From: Bloomer, David <David.Bloomer@lancashire.gov.uk>
Sent: 02 June 2016 14:37
To: Rebecca Halliwell
Cc: LHS Customer Service; planning
Subject: app3/2016/0429 former Police House , Chipping

Proposed Site Plan
 1:100

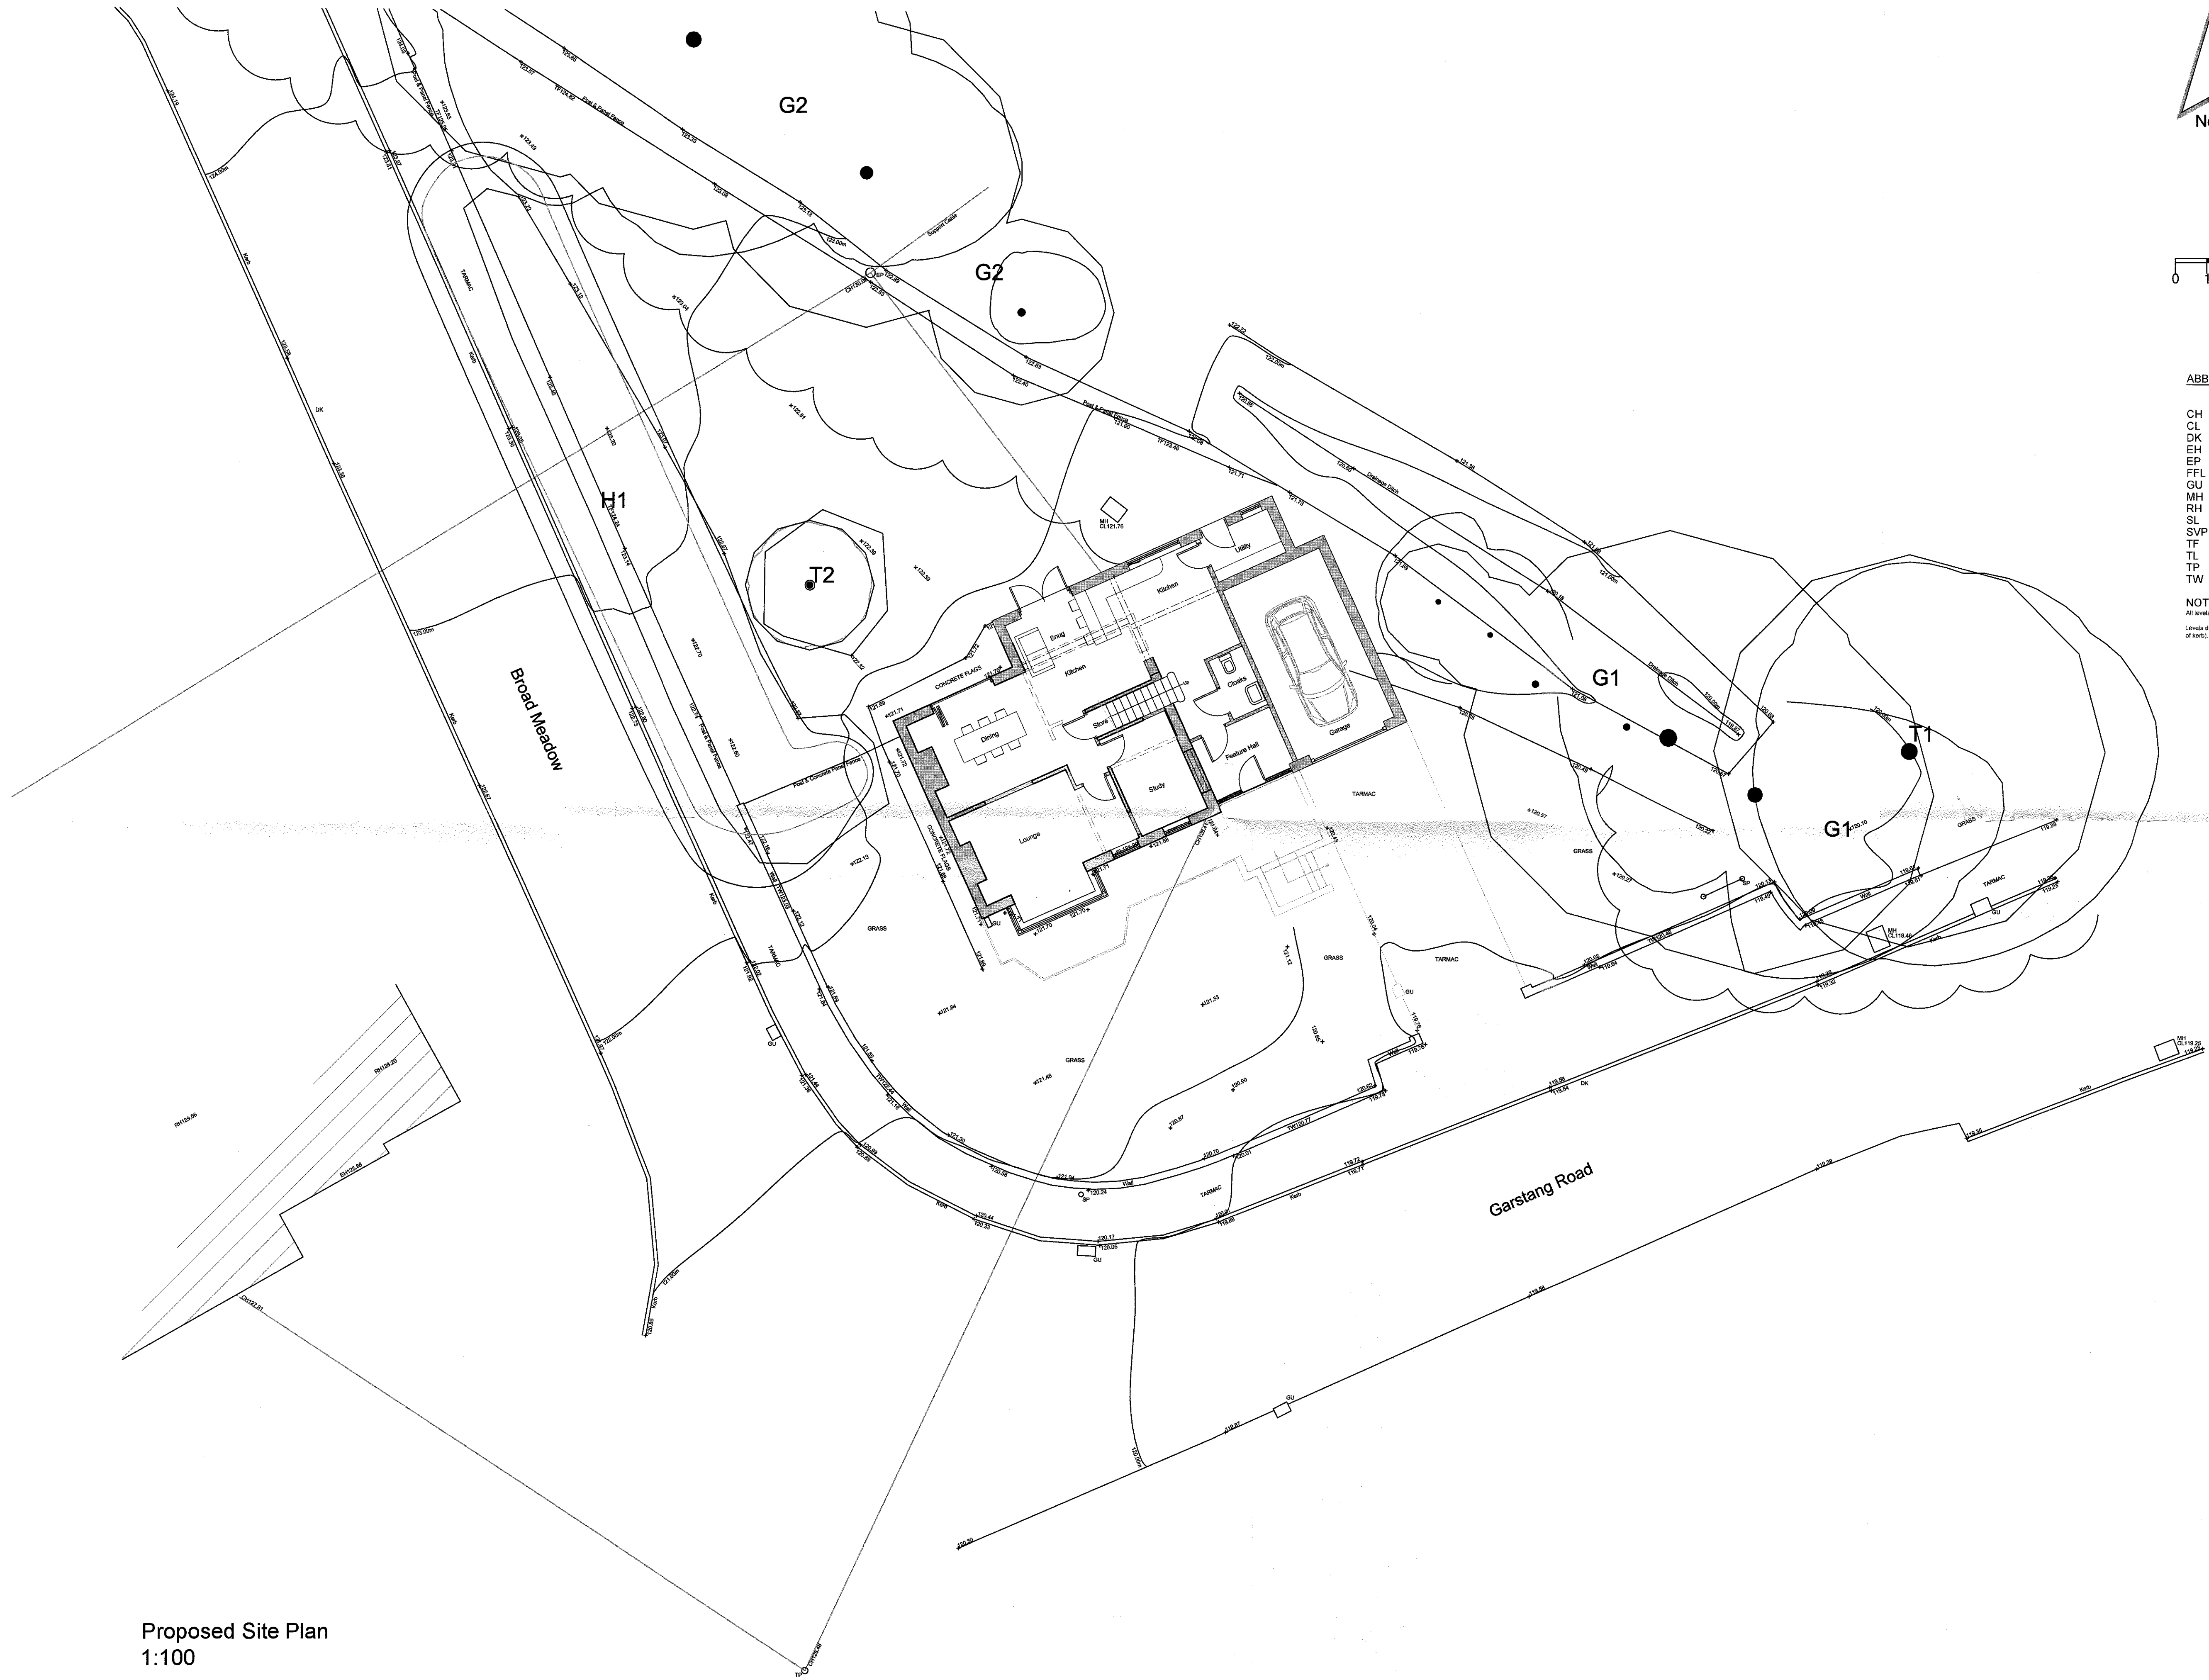
The proposal is for a 4 bed property which would attract a parking provision of 3 vehicles. Unfortunately the driveway is scaling at only 9.5m which would only accommodate a single vehicle. The garage is acceptable as a parking space so the applicant would need to provide an additional parking space on site. Also it is unclear from the submitted plans who owns the hedge to the eastern boundary of the site. There is a short section adjacent to the footway which impinges on the sightlines and if possible this should be removed.

Finally the vehicular access is narrow and would benefit from widening to assist with manoeuvrability to / from the site.

Subject to the above being resolved satisfactorily I would raise no objection to the proposal on highway grounds
